PLANNING CONSULTATION RESPONSE

Application No	2026/0482
Proposal	Change of use of garage from domestic (Use Class C3) to be used as a commercial beauty salon (Use Class Ec2)
Address	18 West Crescent, Oxspring, Sheffield, S36 8YU
Date of Consultation Reply	22/07/26
Consultee	Highways DC

Site Layout - Proposed
18 West Crescent, Oxspring, S36 8YU

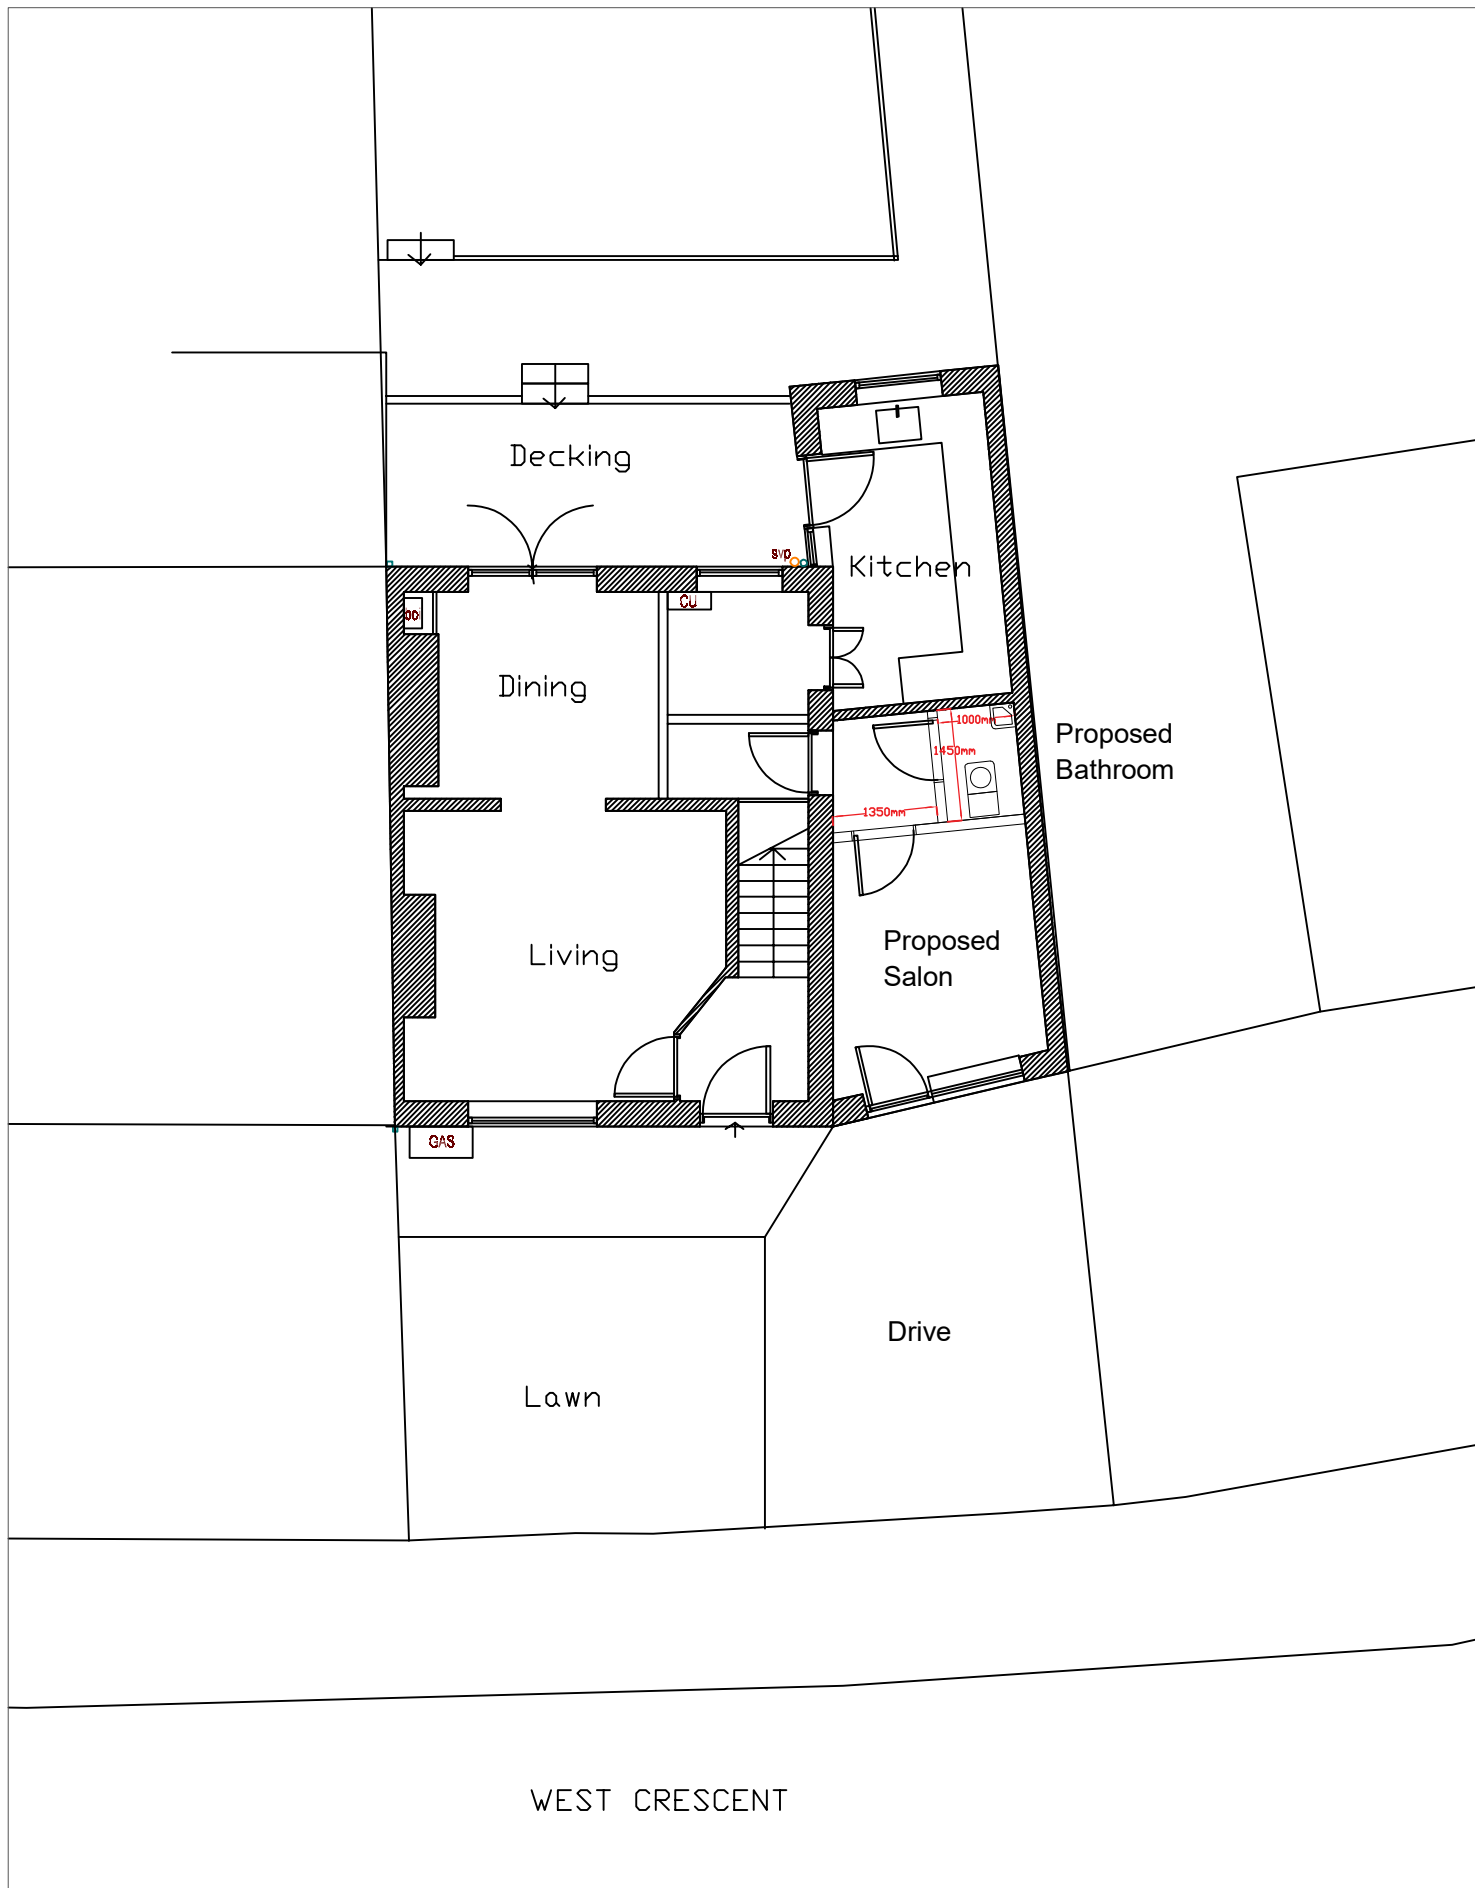
The existing driveway is only wide enough to comfortably accommodate one vehicle, measuring at approximately 4.2m wide on the submitted layout drawing. As one off-street space would be required for customers, HDC officers would ask that the driveway is widened to the minimum dimensions of 4.8m in width and 5.0m in depth.
